Re: Dell's Nursery Rezone – *Technical Review 2*  
PA 22041

After reviewing the revised application materials for the above referenced proposal, the Planning Division has the following comments:

Preliminary Site Plan

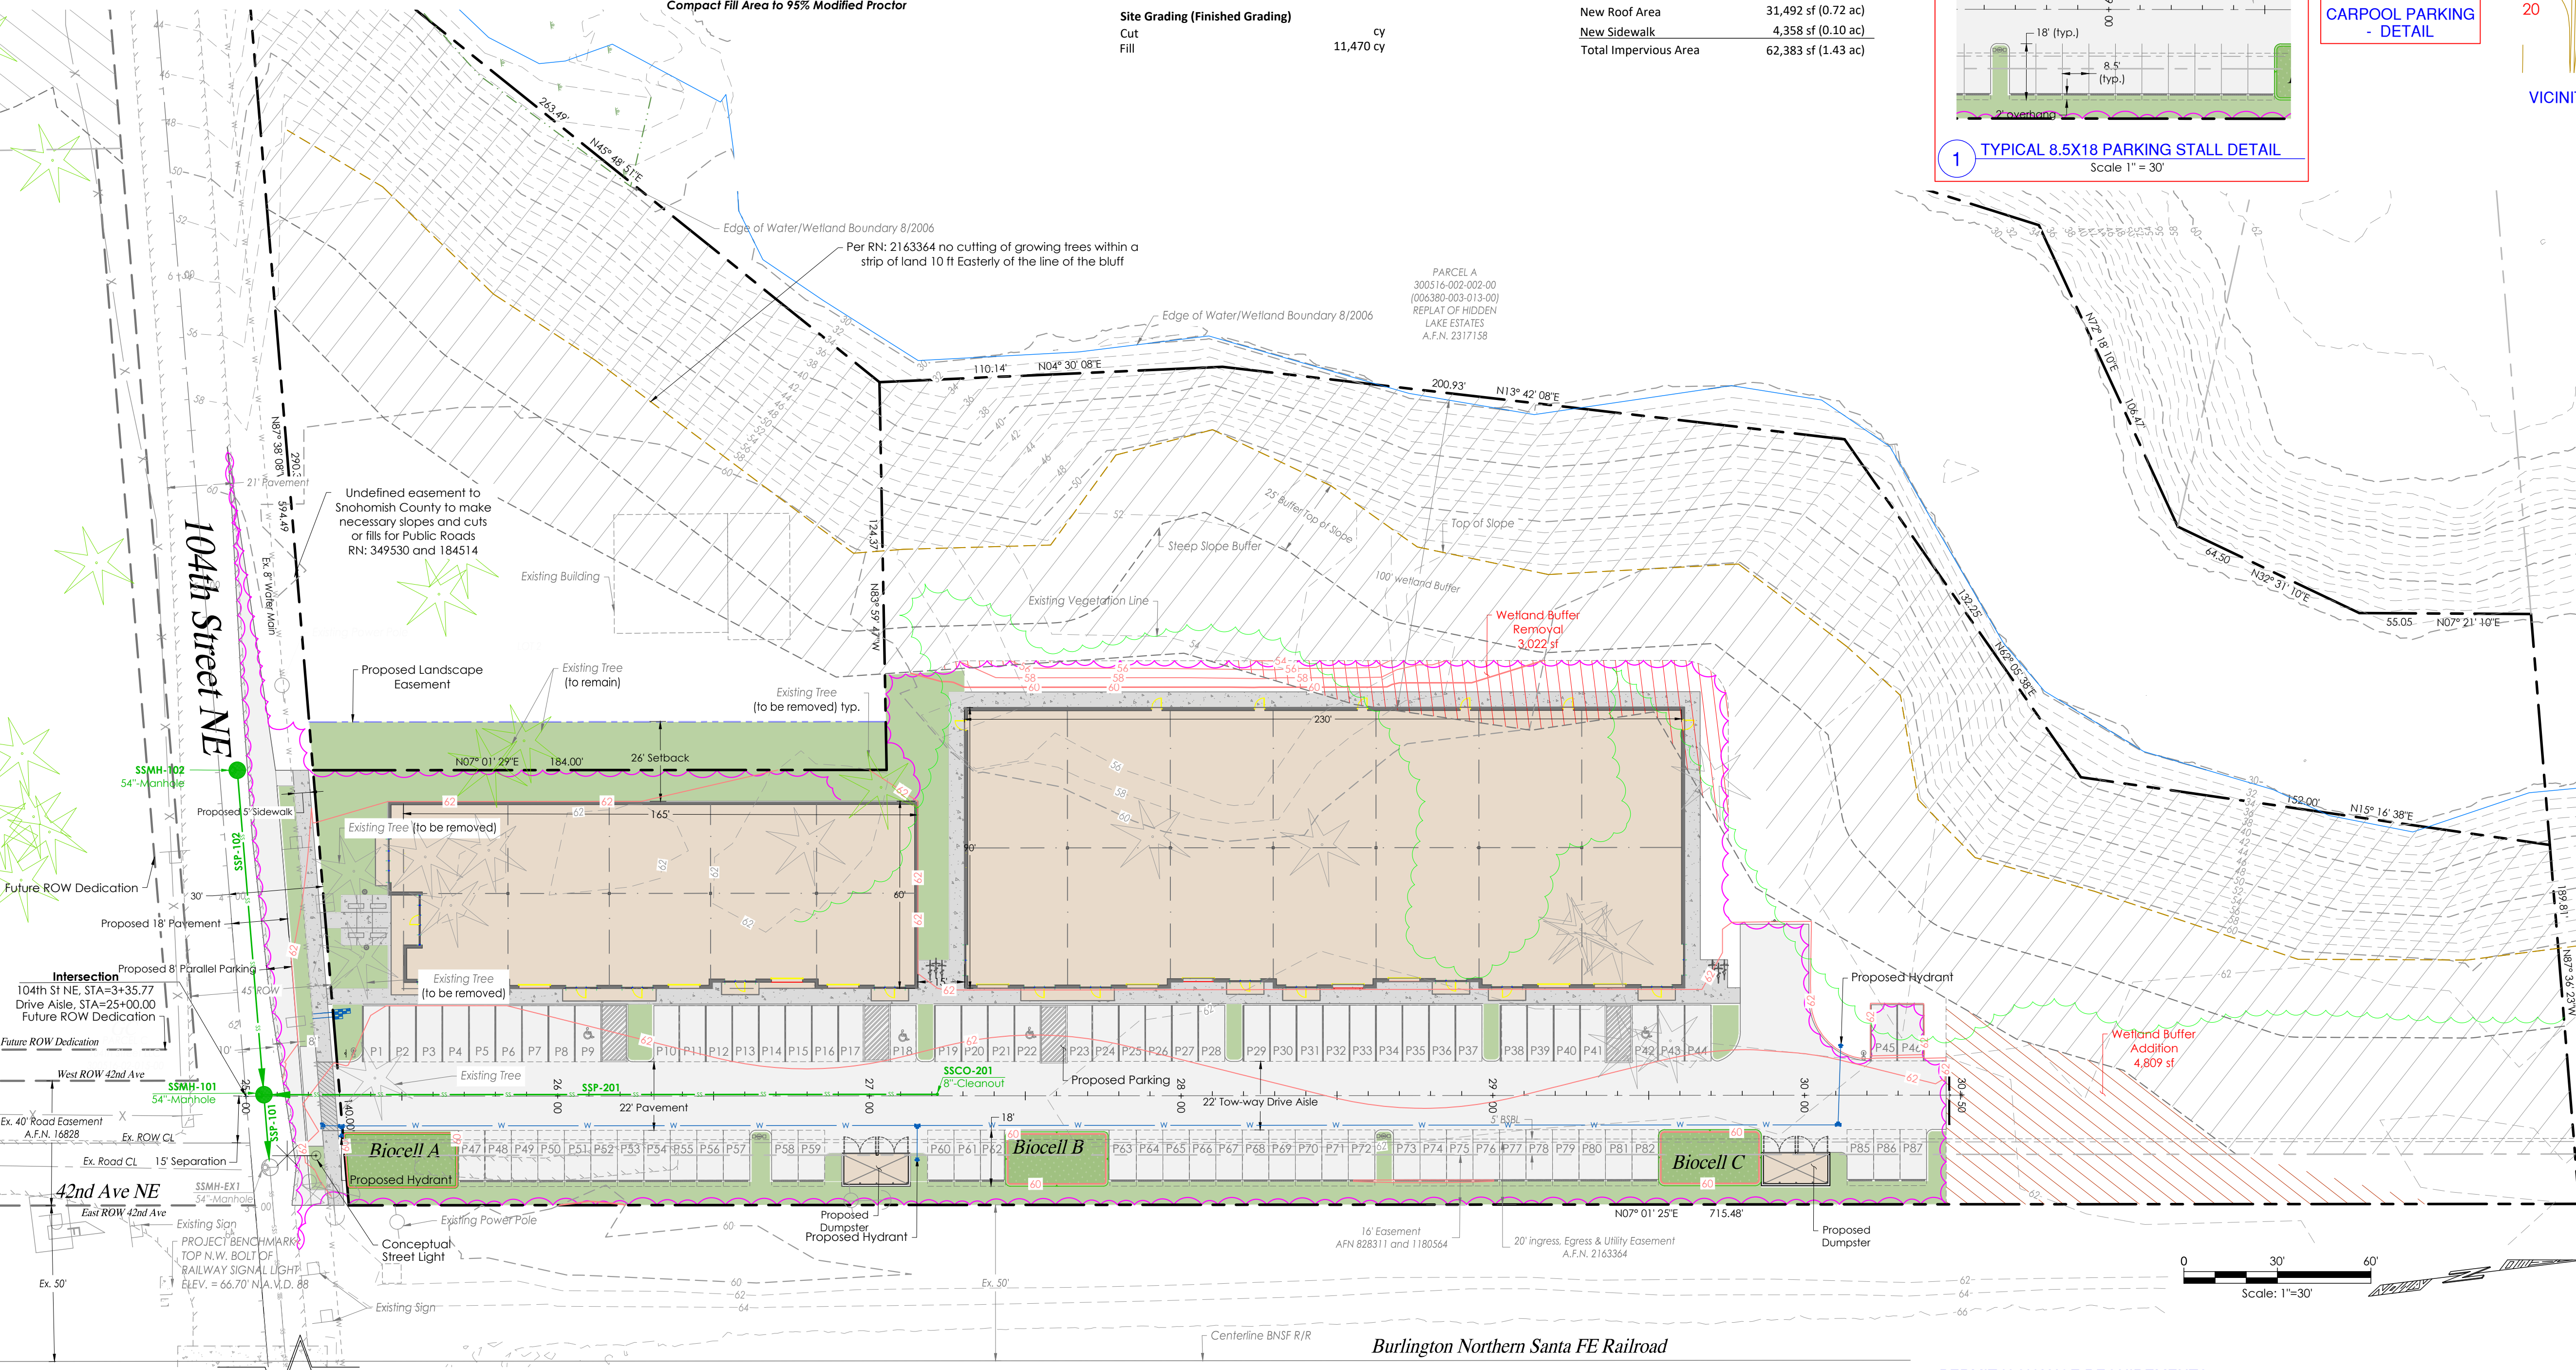
1. Amend Sheet P1, as follows:
  - a. Identify location of proposed carpool parking stalls. Pursuant to MMC 22C.130.030(3)(b) carpool parking spaces shall be closest to the building entrance, but not closer than ADA spaces.

- b. Amend "22' Tow-way Drive Aisle" to read Two.
2. Prior to civil construction plan approval a FINAL critical areas mitigation plan shall be required to be submitted, in accordance with MMC Chapter 22E.010 *Critical Areas Management*. Additionally, the preliminary buffer mitigation plan states monitoring is required for 3-years, however, pursuant to MMC 22E.010.160(2) security for performance and maintenance shall be for a period of five years.
